Your ref: 2024/62/93068/E – Planning application, 1 Chadwick Crescent WF13 2JF. Erection of two storey side extension, single and two storey rear extension and front extension.

I write in connection with the above planning application. I strongly object to the proposed development, a similar application was refused on 22.08.24.

DESCRIPTION:
GROUPED EXISTING AND PROPOSED
STREET SCENE

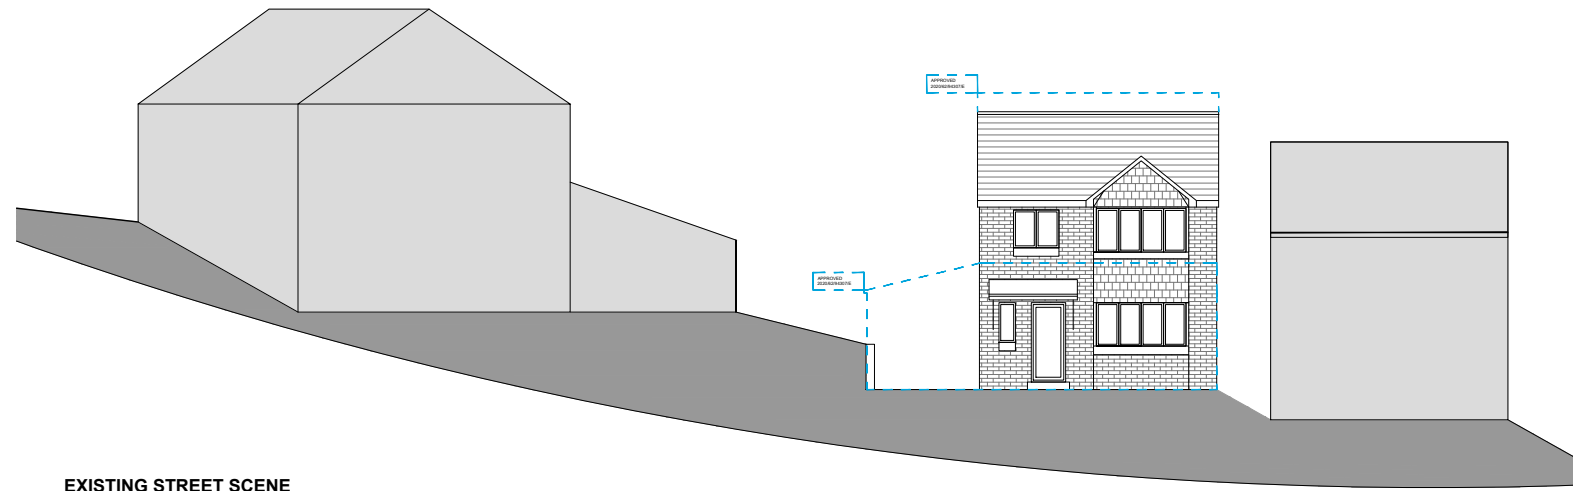
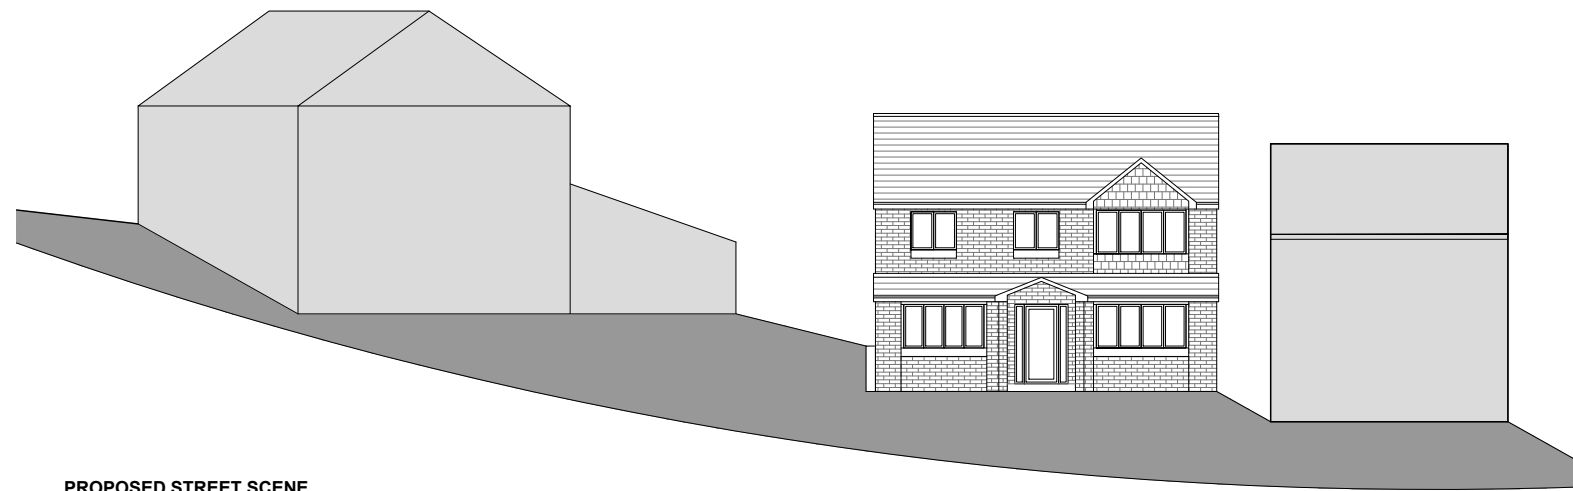
15 Infirmary Road sits on elevated ground and has been extended. The proximity of the side extension together with the proposed two storey height would result in a substantial massing along the shared boundary of the properties. This would have a detrimental and overbearing impact on the residents and visitors of 15 Infirmary Road due to the increased proximity of the properties post construction - this would be at a distance of less than 3 meters at the closest point. The two-storey side extension of the host property would look directly on all rear room's windows as well as the rear amenity space. It would also negatively impact on the privacy of rear amenity space enjoyed by 11 Infirmary Road. There would also be substantial overshadowing, loss of light along the boundary. The proposal therefore fails to comply with LP24C of the Kirklees Local Plan, KDP5, KDP6 of the House Extensions and Alterations SPD and chapter 12 of the National Policy framework.

The visual amenity currently afforded and enjoyed by neighbouring properties would also be diminished. The large scale, design and location of the proposed development would result in an overbearing and oppressive impact on number 3 Chadwick Crescent. If built it would be obstructive and incongruous feature, which would not relate satisfactorily to the character and appearance of existing surroundings.

Whilst I note this application has slightly reduced the size of the proposed development from the previous application, the reality is it makes minimal difference. All the concerns raised by me previously remain equally valid now. The proposal effectively means I would look directly onto 20 meters of brick walling in length at ground level and over 9 meters at first floor level. This would decimate the visual amenity currently afforded to myself, the owners of 15 Infirmary Road and other neighbouring properties.

PROPOSED GROUND FLOOR PLAN
 SCALE 1:100 @ A1

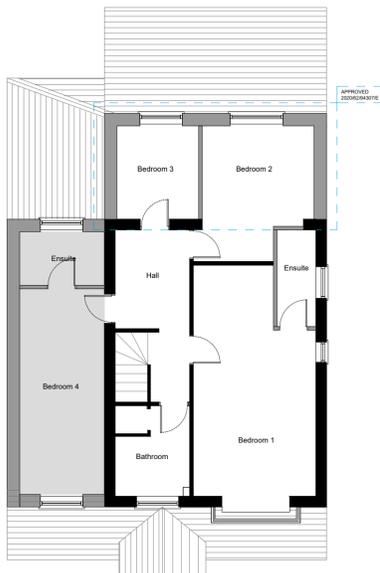
There are trees protected by a Tree Preservation Order (TPO) located within the garden of the proposed development and the garden of 15 Infirmary Road. The trees provide significant amenity value to residents and users of both Infirmary Road and Chadwick Crescent. The proposed front extension is positioned within the tree's root protection area, this is not shown on the plans. The tree survey submitted by the applicants is dated 2021 this is now outdated and does not correctly map the canopy or root areas as the trees have grown in size. Additionally, given the height and species of the tree, the canopy/crown spread of the tree clearly overhangs the front and side of the site and this would result in the dwelling being heavily shaded. All of this is highly likely to result in an increase in pressure to either prune or fell the tree in the future. The development would therefore prejudice the continued viability of the protected tree, contrary to policies PLP, 24 (as modified) and PLP, 33 (as modified) of the Kirklees Publication Draft Plan.

PROPOSED SIDE ELEVATION
 SCALE 1:100 @ A1

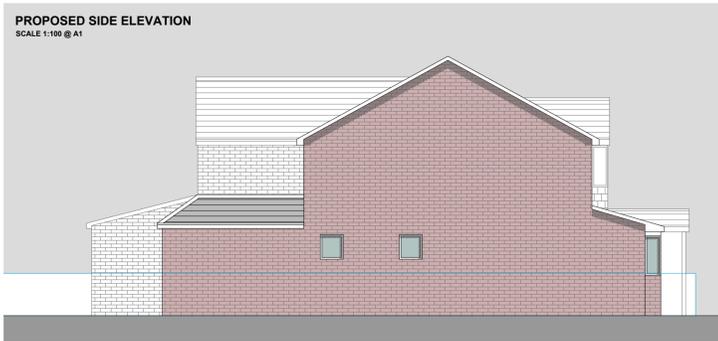
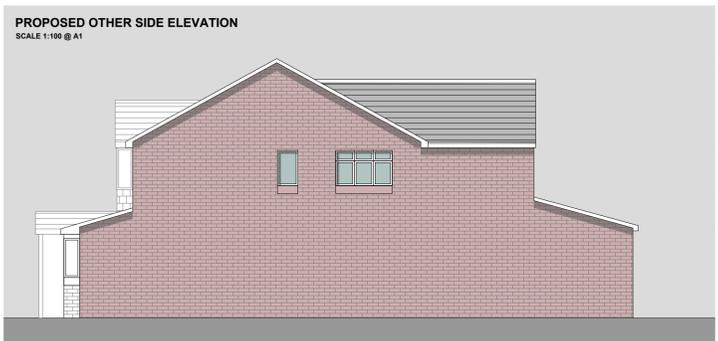
The plans reveal several windows along the side extension, these windows would result in a loss of privacy for neighbours and I. This would infringe on Article 8 of the ECHR.
